**CITY OF PORTLAND, MAINE
DEVELOPMENT REVIEW APPLICATION
PLANNING DEPARTMENT PROCESSING FORM**

10/6/2004
Application Date
156 Hope Ave / Presumpscot River Pla
Project Name/Description

TO: JAY REYNOLDS DEVELOPMENT REVIEW COORDINATOR CITY OF PORTLAND PLANNING AND DEVELOPMENT	DATE: OCTOBER 25, 2004
	JOB NO.: 26885
	FROM: JOHN RANSOM
RE: LOT 9, PRP III

From: Jay Reynolds
To: John Ransom
Date: Tue, Oct 19, 2004 4:12 PM
Subject: Lot 9, PRP III,

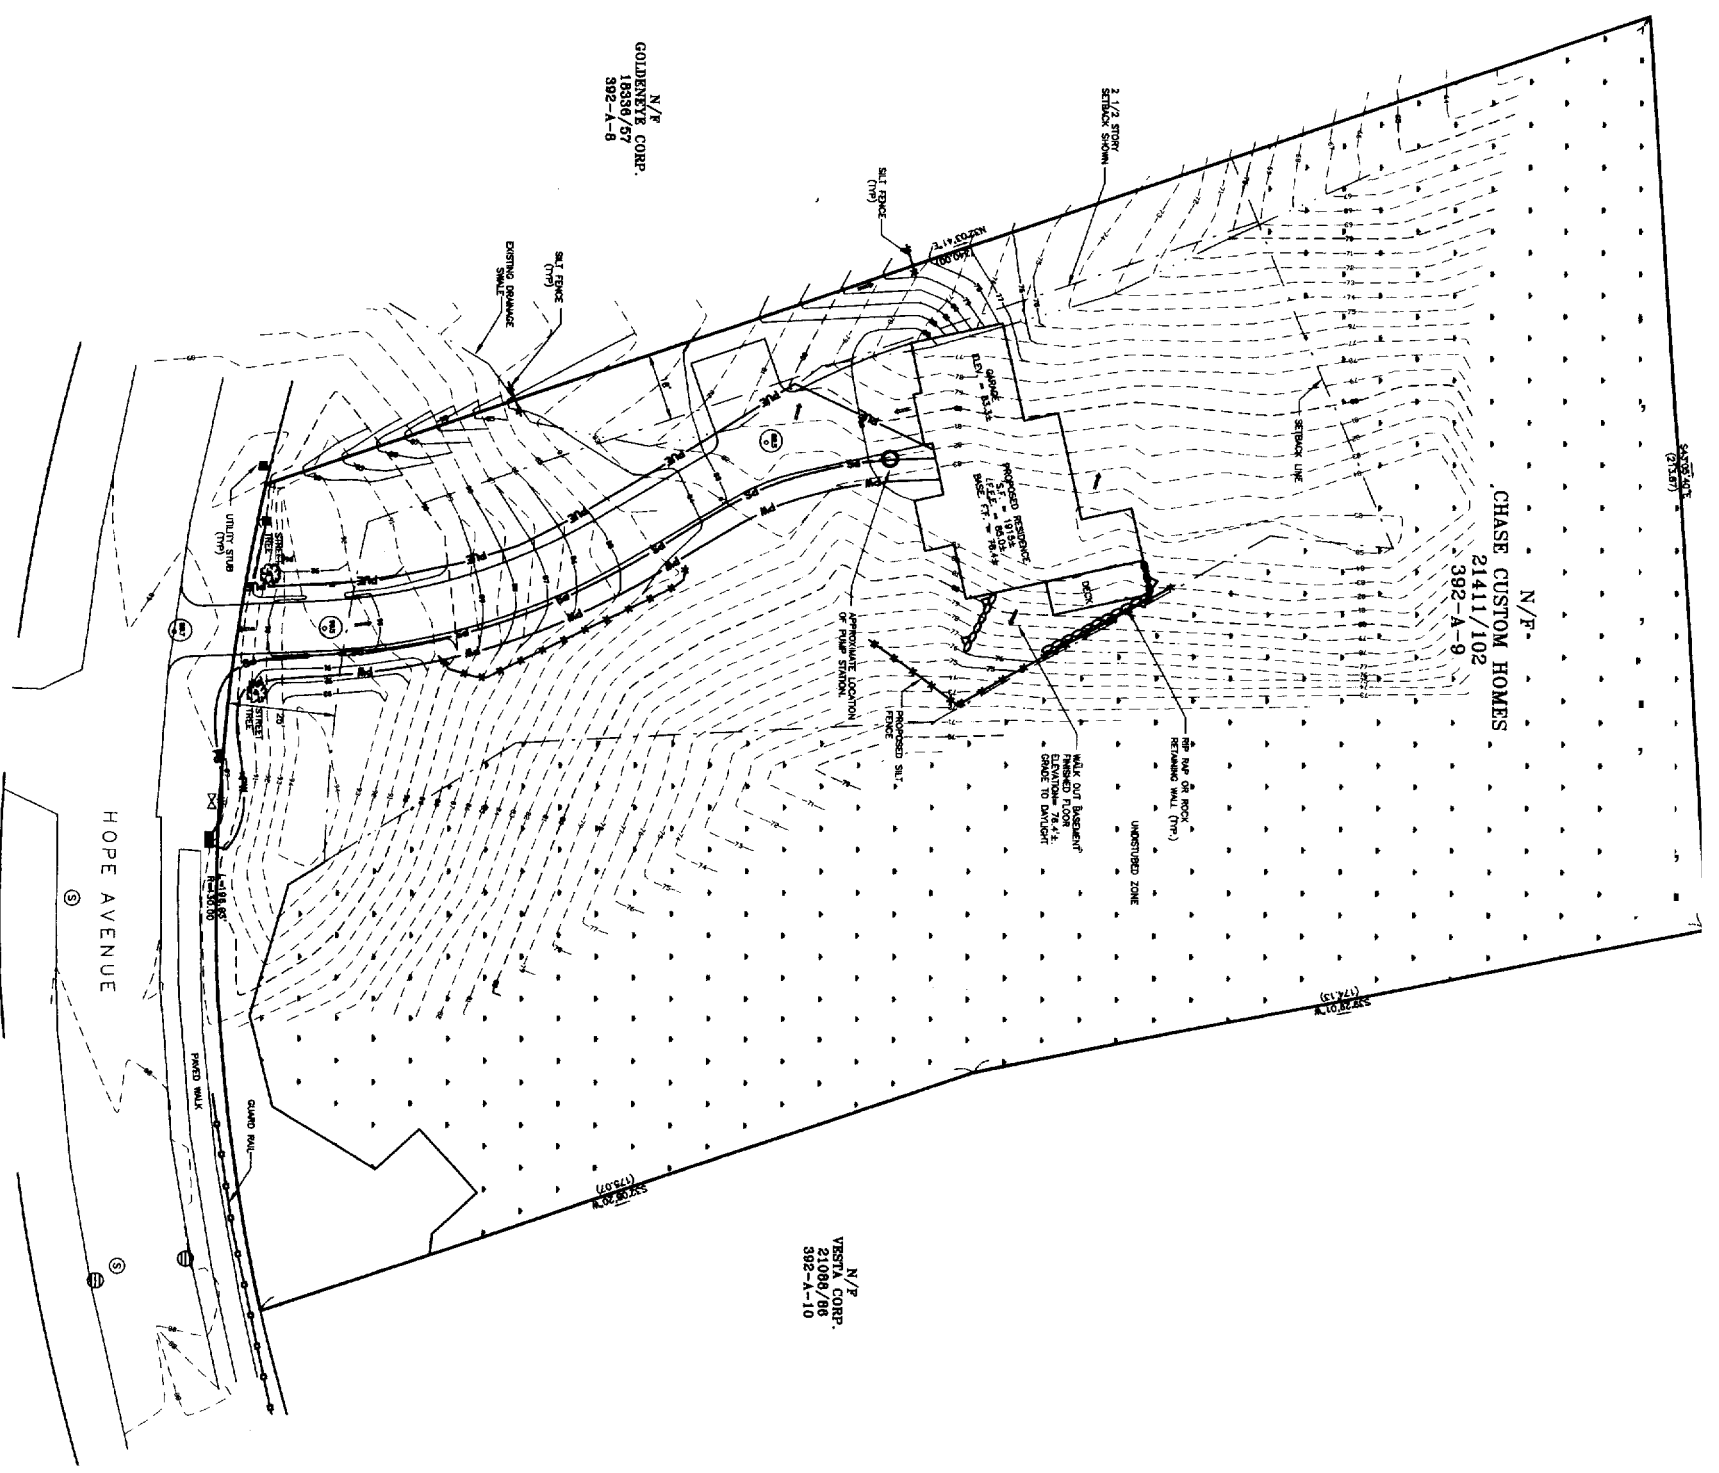
1. Please indicate the height/elevation of the proposed retaining wall.
2. Topography in rear of building: There is no proposed grade changes in the rear of the building. The building elevations would suggest that grading would occur. Please clarify.
3. Please show location of foundation drain, and outlet, if proposed.
4. Please remove the curve or 'sweep' in the force main and water services so that it doesn't meander in and out of the right of way.
5. The actual curb cut is approximately 13 feet from the left side property corner. Please verify curb cut location on your plan and readjust driveway alignment, if needed.

Jay,
Thank you for your review comments – I believe we have addressed all of them. Please note that the two windows in the “office” in the basement will need to be eliminated due to grading restrictions. The driveway now matches the newly constructed curb cut which did not exist at the time of our field survey. In your e-mail of 10/19/2004 you mentioned the curb cut was 13 feet left of the property corner, it is 13 feet left of where an extension of the property line meets the edge of the pavement.
John Ransom
